SUBMISSIONS ON MP 07_0167 NIELD AVENUE GREENWICH FROM THE PUBLIC AND AGENCIES

Part A – Public submissions

Part B – Agency submissions

**SHADOW DIAGRAMS
- 22nd JUNE**

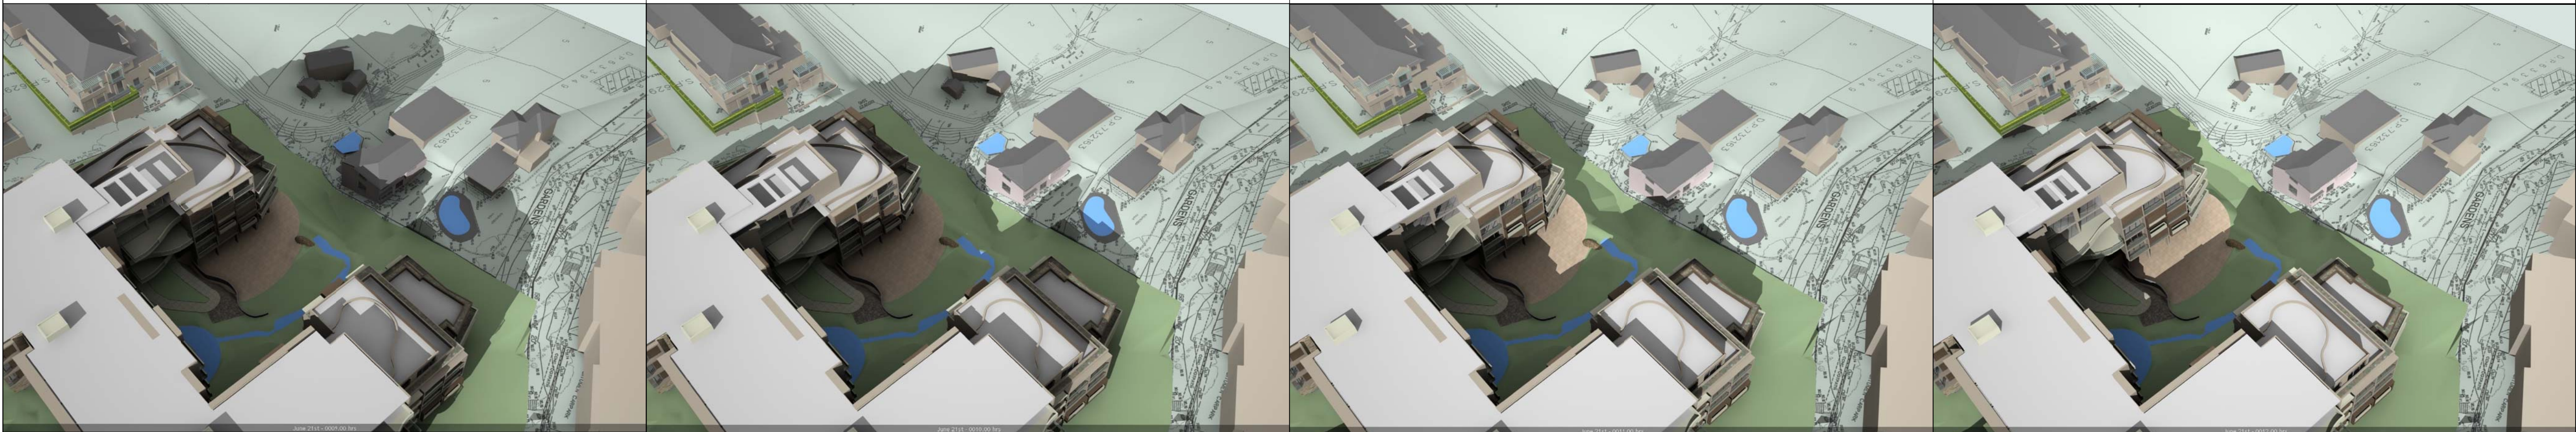
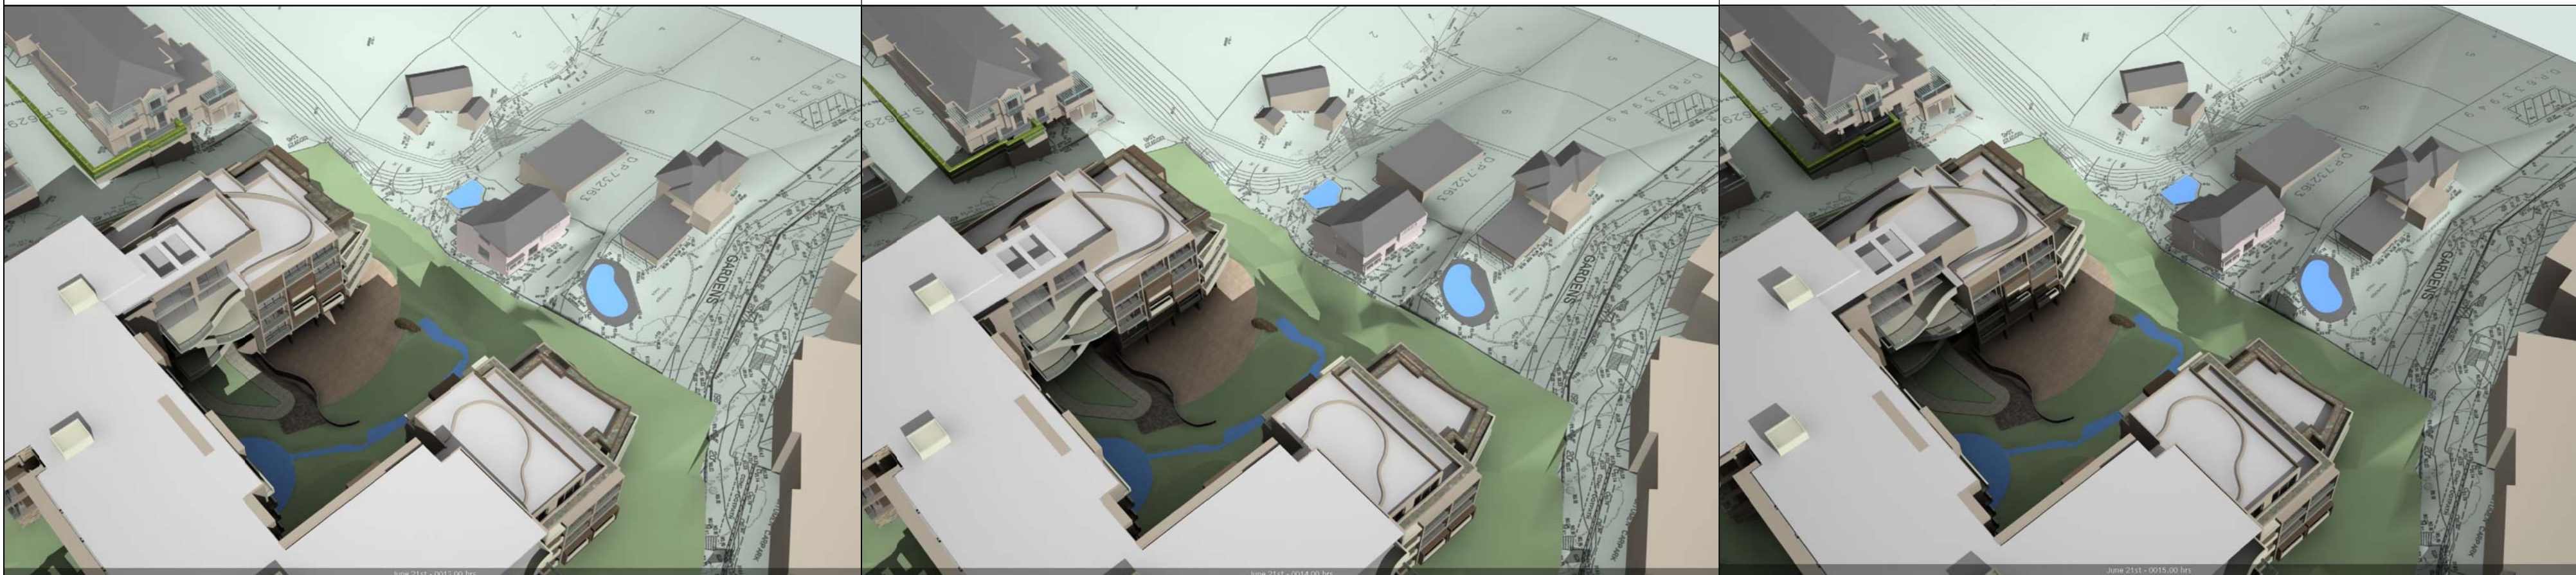
- Shadow diagrams are inaccurate - Building will result in significant overshadowing, overlooking and light spill for 6 Morven Gardens - Building height and setback should be amended to reduce impacts including removal of central courtyard with plantings provided in the setback - Solid bamboo screens of adequate height should be erected to prevent overlooking into all adjoining properties, uninterrupted windows to dining areas and all windows facing 6 Morven Gardens should be deleted - Height is greater than existing buildings in locality and does not comply with the existing or draft LEP, building should be redesigned to take account of slope and height of existing buildings - Existing vegetation on adjoining properties should not be relied on for screening purposes - Terrace and dining areas should be relocated away from adjoining dwellings to reduce noise impacts - Large plant room will cause noise and should be relocated away from south west boundary to location which will not impact adjoining dwellings - Development of a hospital will have a detrimental impact on property values - Excavation, building works, dust and odours will impact surrounding residents
